<b>Application Reference Number:</b>	2026/0168.
--------------------------------------	------------

<b>Proposal Description:</b>	<i>Change of use and conversion of part of a sales/display area (Use Class E) to create 1no. residential unit (Use Class C3).</i>
------------------------------	---

<b>Location:</b>	<i>Unit A, Priory Arms Rotherham Road, Cundy Cross, Barnsley, S71 5RF.</i>
------------------	--

PROPOSED

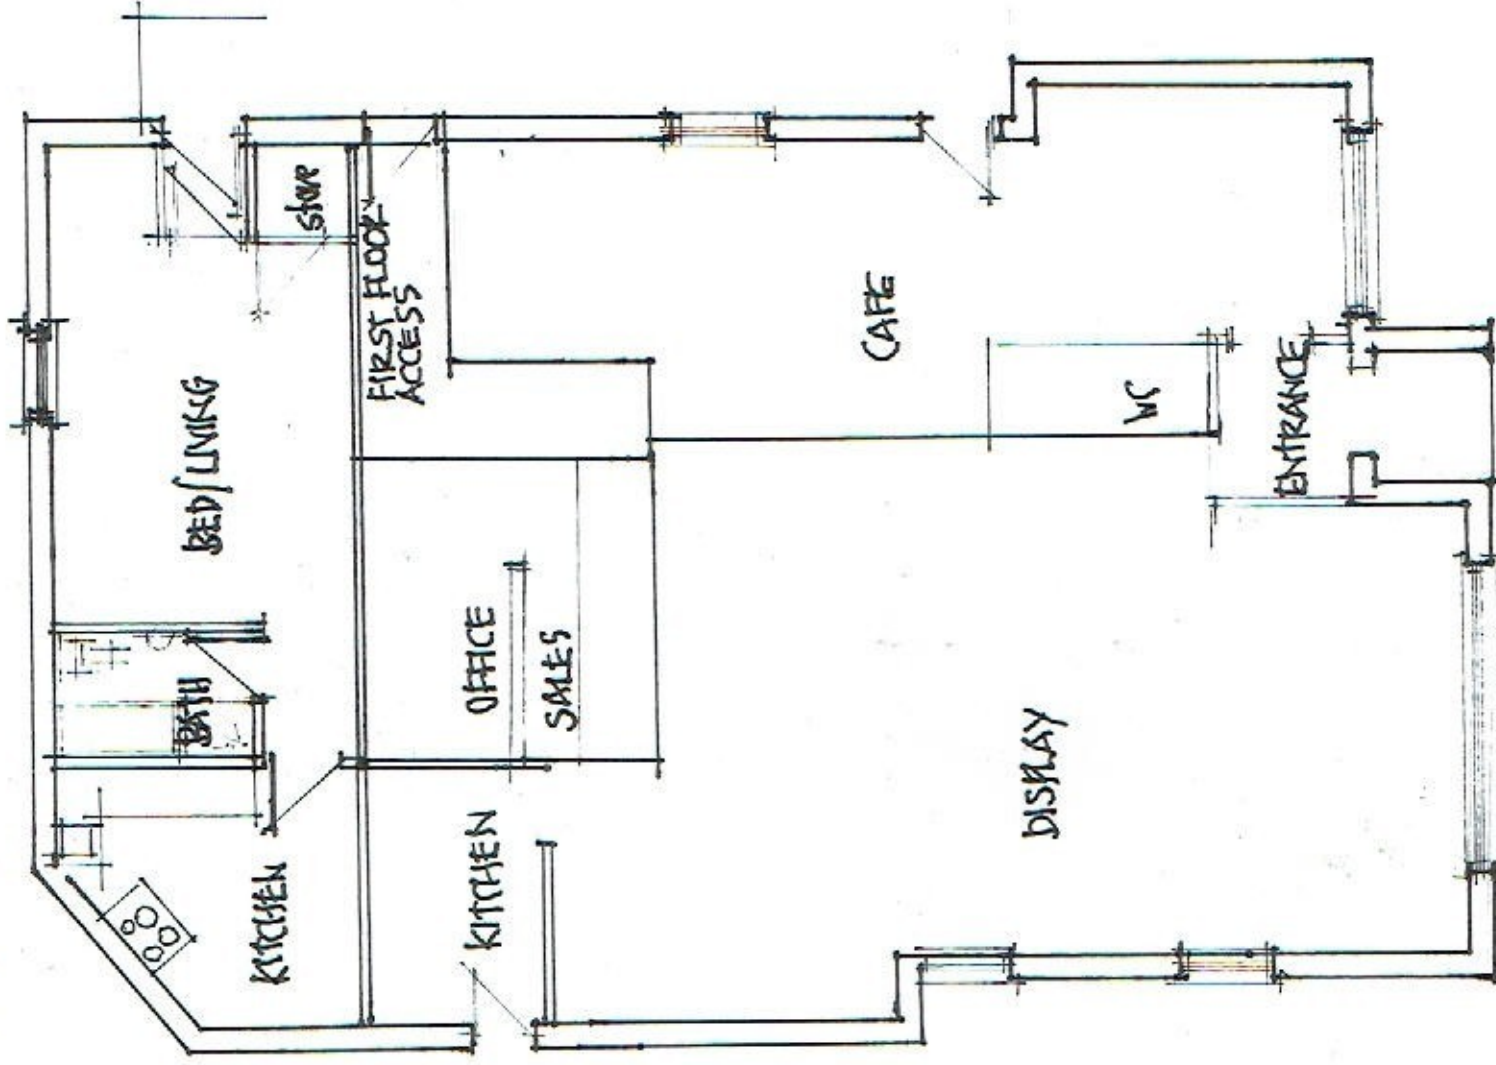
However, the Local Planning Authority (LPA) does not consider that the proposed residential unit would constitute a one-bedroom flat or a studio as to be a studio the layout should comprise a single room comprising a living room, kitchen and bedroom with a separate bathroom.

Notwithstanding the above, the kitchen would not be served by a window and the bedroom and living area would only be served by one modest-sized window. This is considered to be unacceptable, and it is likely that the proposal (as submitted) would not achieve reasonable access to natural light with significantly reduced levels of outlook.

The existing window located on the north elevation of the building that would serve the bedroom and living area would also look out to an area of the development site that is utilised as an enclosed bin store in an unkept state. This is undesirable and would be unpleasant for any potential future resident and would not ensure safe and healthy living conditions contrary to paragraph 124 of the NPPF and Local Plan Policy GD1.

Highways Development Control were consulted and colleagues noted that it is suggested that there would be no changes to the existing car park. However, one space should be reserved for potential residents of the proposed residential unit and the manner in which this would be achieved should be submitted by the applicant. A submitted proposed car parking plan indicated that two spaces would be reserved for the proposed residential unit. However, while parking spaces have been marked out on the submitted plan, on-site observations show that the car park is not marked out, and therefore, the proposal does not accurately reflect the current situation. Highways colleagues suggest that the layout should be amended to reflect the actual car park layout.

Highways Development Control colleagues also noted that while a cycle and bin store are shown on the submitted plans, the dimensions of these have not been shown. Colleagues suggest that the bin store should be of sufficient size to accommodate three residential bins and the existing commercial facilities. A cycle store should be covered and capable of being made secure and subject to regular surveillance as per the guidance in the Council's adopted Parking SPD. Highways colleagues state that these details should be included on any amended layout and include dimensioned and precise labels.
